Application for a minor material amendment to Planning Permission 21/03347/FUL (as already amended by 22/02041/S73).

Proposal: Demolition of existing dwelling and outbuildings. Erection of a replacement dwelling and outbuilding together with associated works and landscaping.

At: East Lodge The Green Kingham Chipping Norton

West Elevation of Garage
1:100 @ A1

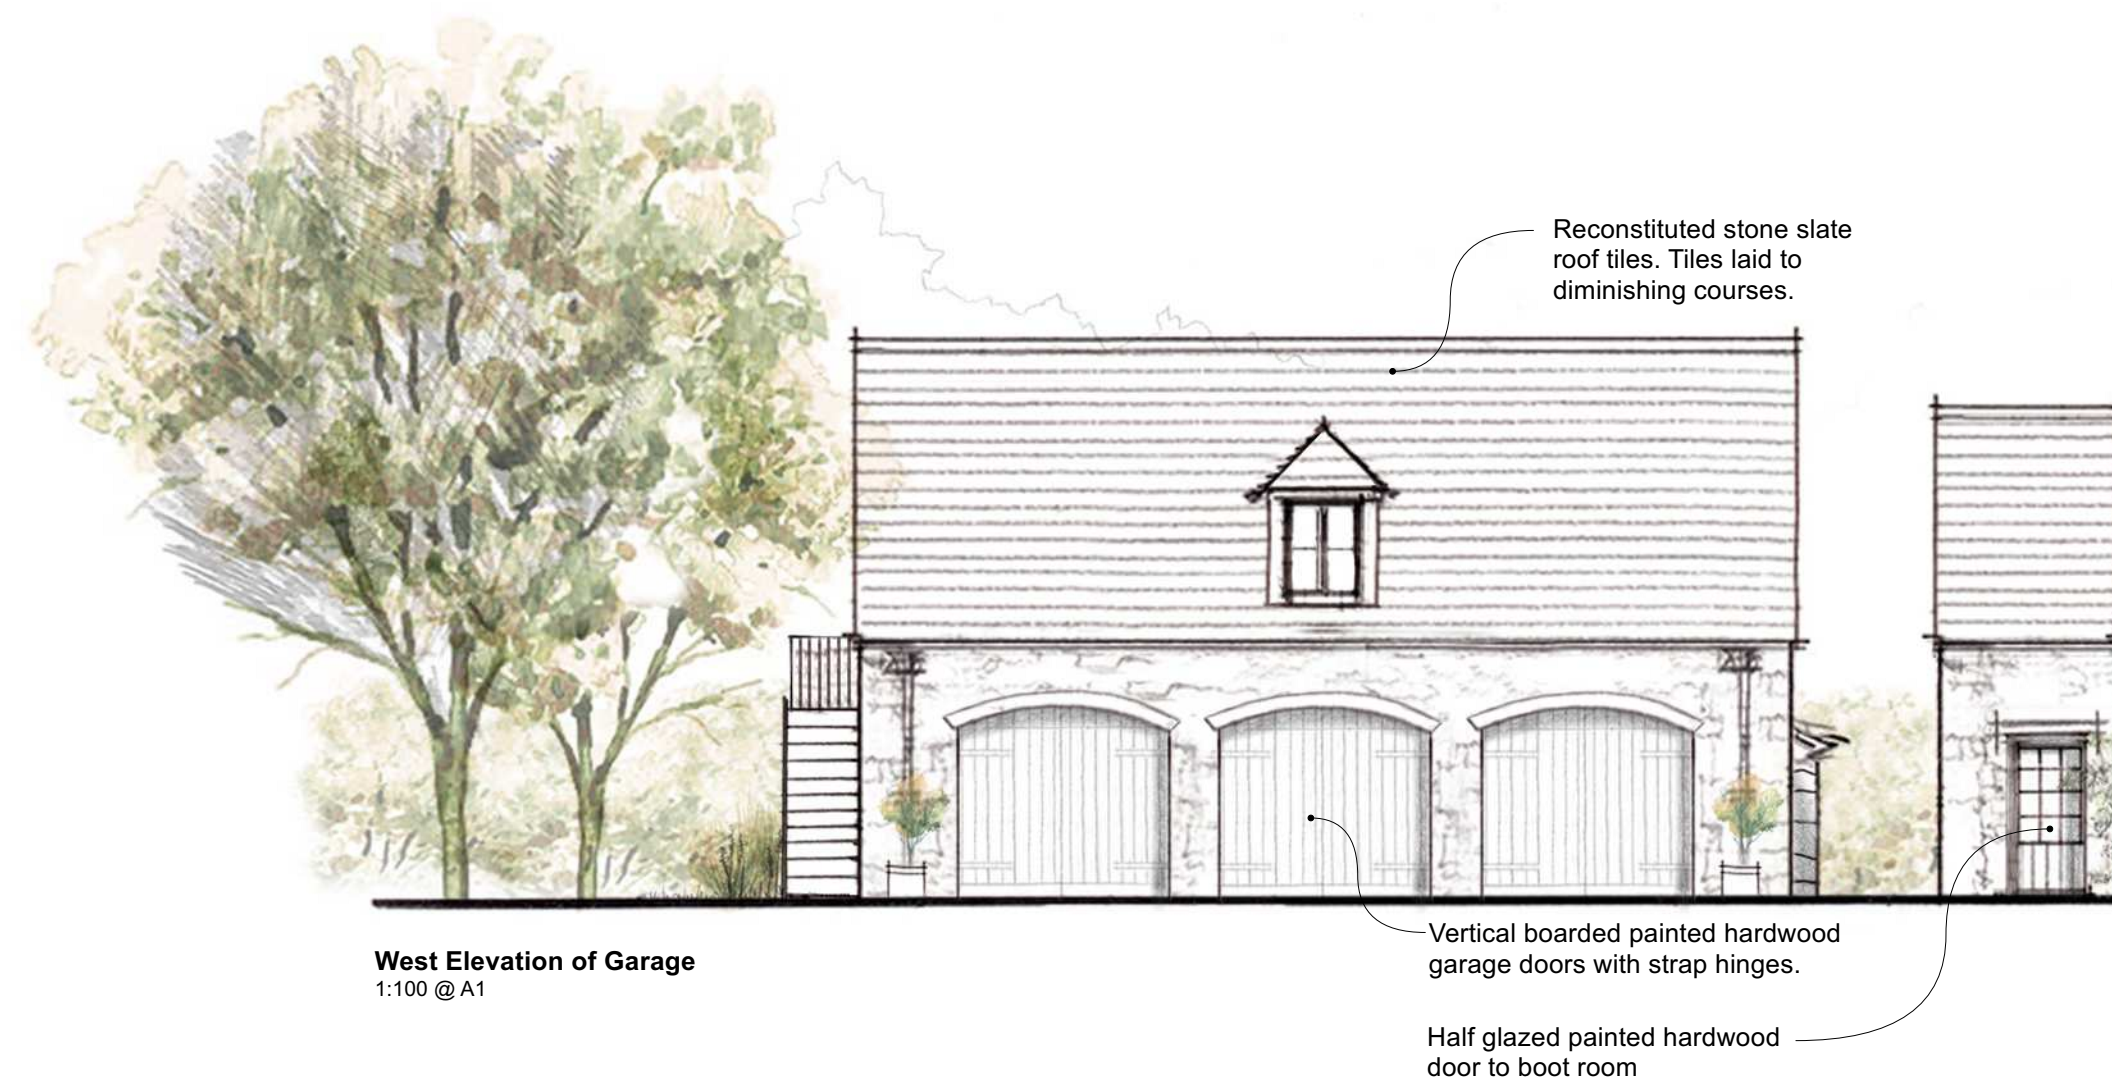
This would replace revision E. It shows the proposed lean to bin store, revised roof materials for the garage, extended eastern wing and includes details of the ecology mitigation for conditions 7 and 11
